Response to Planning application from Hertfordshire County Council (T and CP GDP Order 2015)

District ref: 6/2023/2182/COND
HCC ref: WH/18817/2023
HCC received: 6 November 2023
Area manager: Matthew Armstrong
Case officer: Matthew Armstrong

Land to the north east of King George V Playing Fields Northaw Road East Cuffley EN6 4RD

Submission of details pursuant to condition number 14 (Theobalds Road Route) on planning permission S6/2015/1342/PP

BITUMINOUS MATERIAL TO BE IN ACCORDANCE WITH BS EN 13108-1:2006.

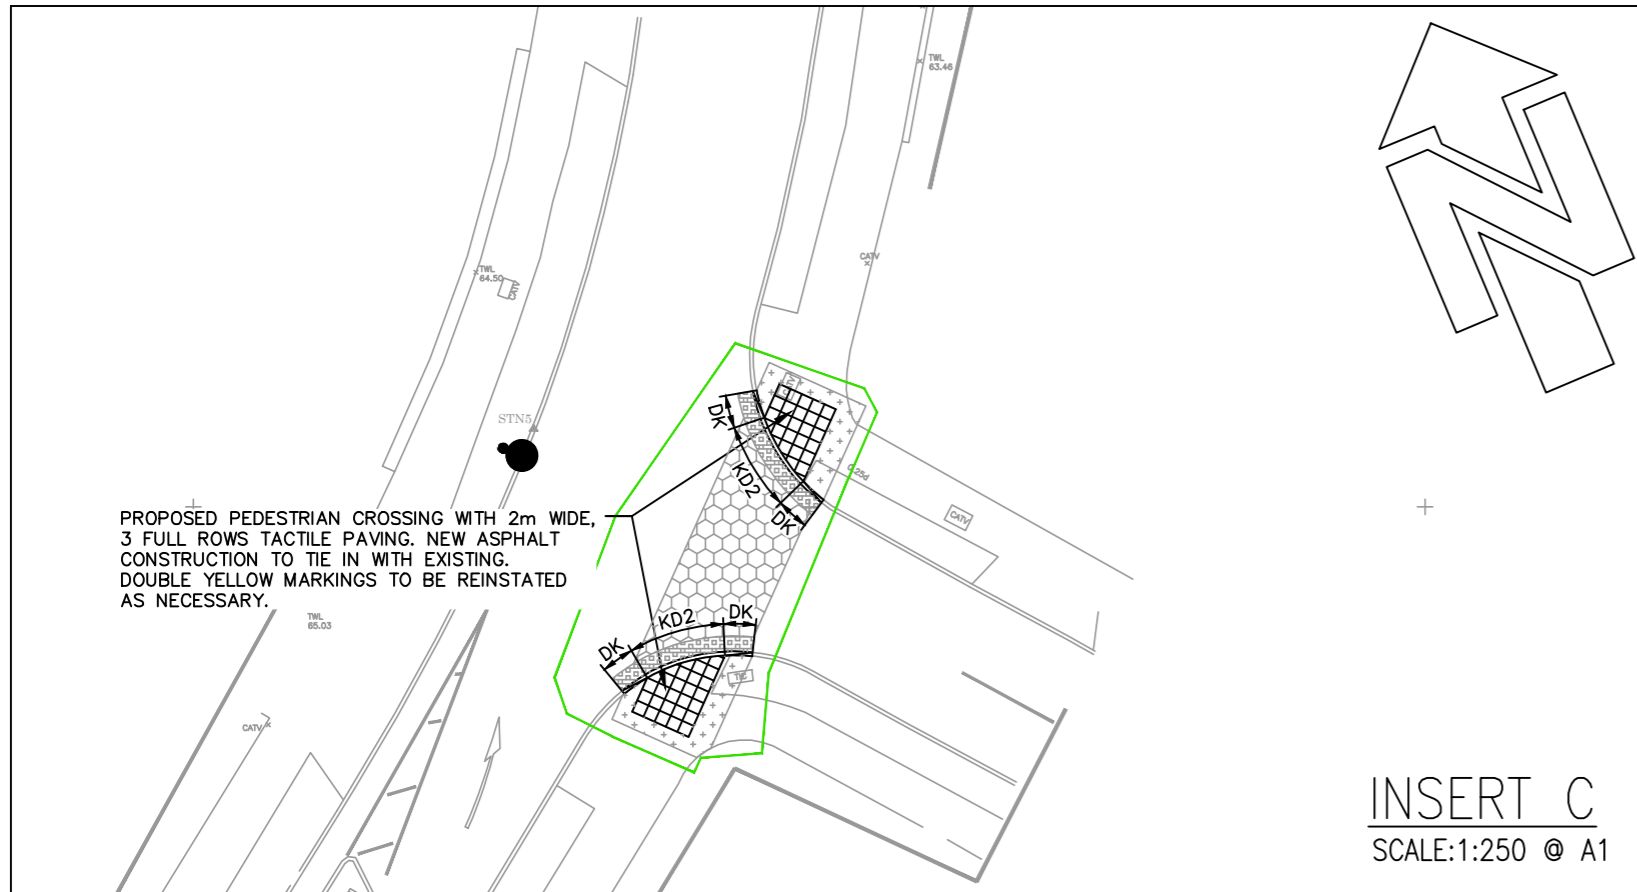
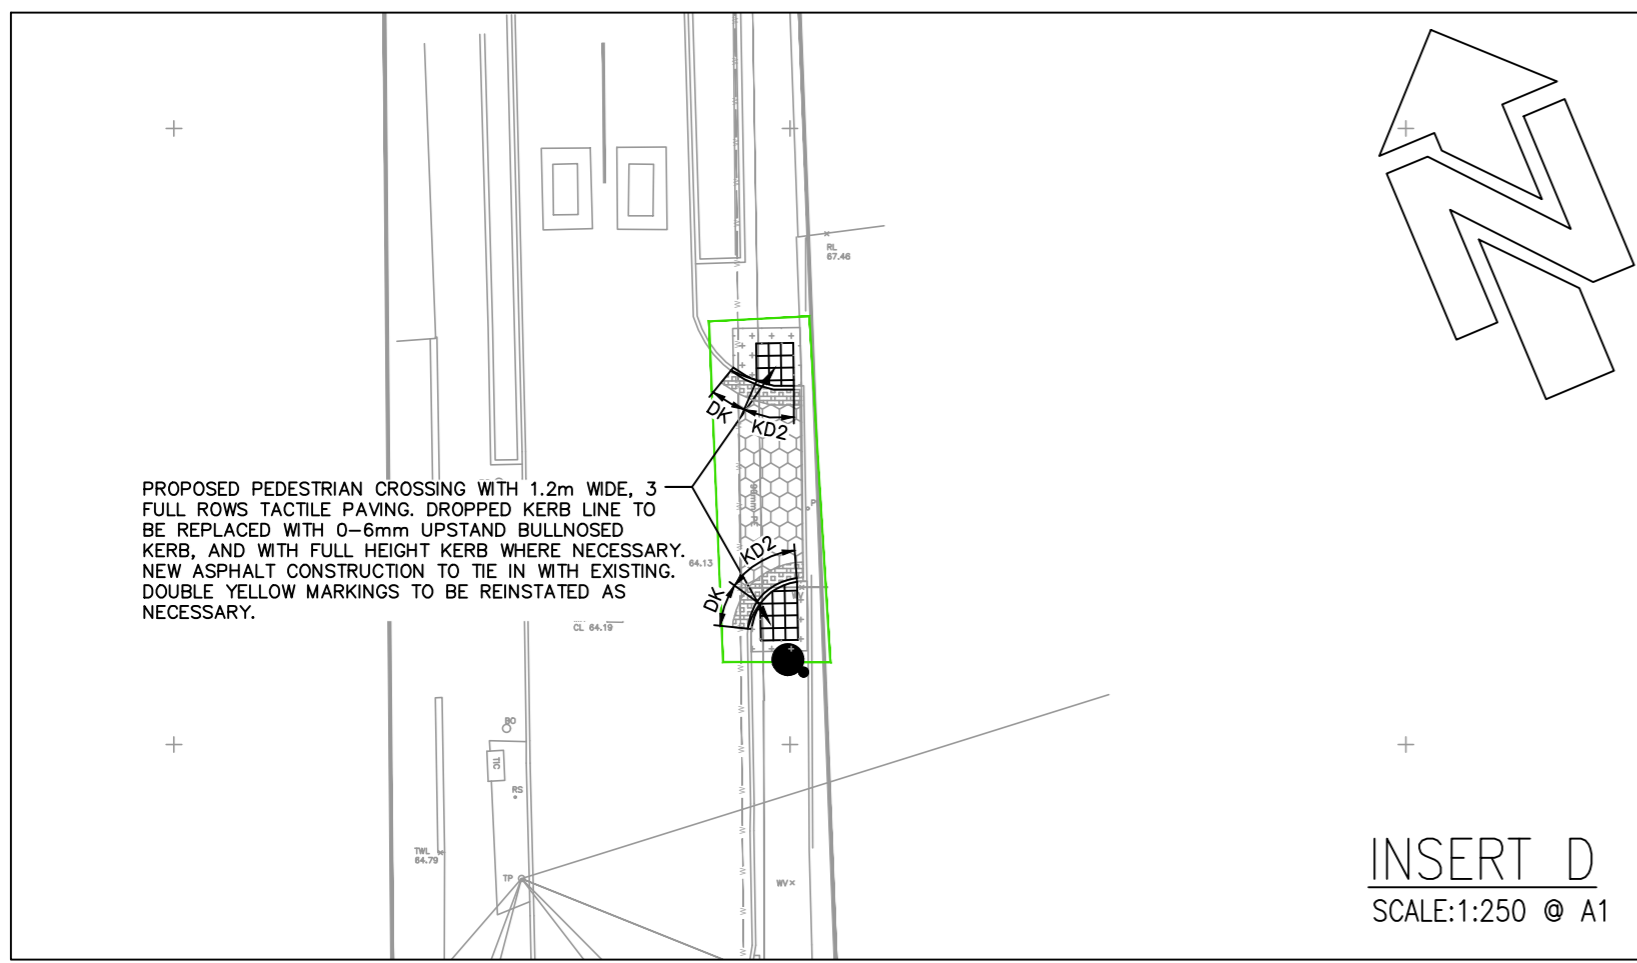
COMMENTS: The condition requires submission and approval of detailed engineering drawings (i.e. approved s278 plans). For this planning application, the applicant has submitted earlier s278 plans which have not received Technical Approval. As part of the stage 2 Road Safety Audit / s278 process, it was identified that there is a need for these plans to be revised, albeit only slightly. Once the latest s278 plans (with Technical Approval) are submitted as part of this discharge of condition application, the first part of the condition can be discharged. As the works are not in place on the ground, it is premature to discharge the second part of the condition.
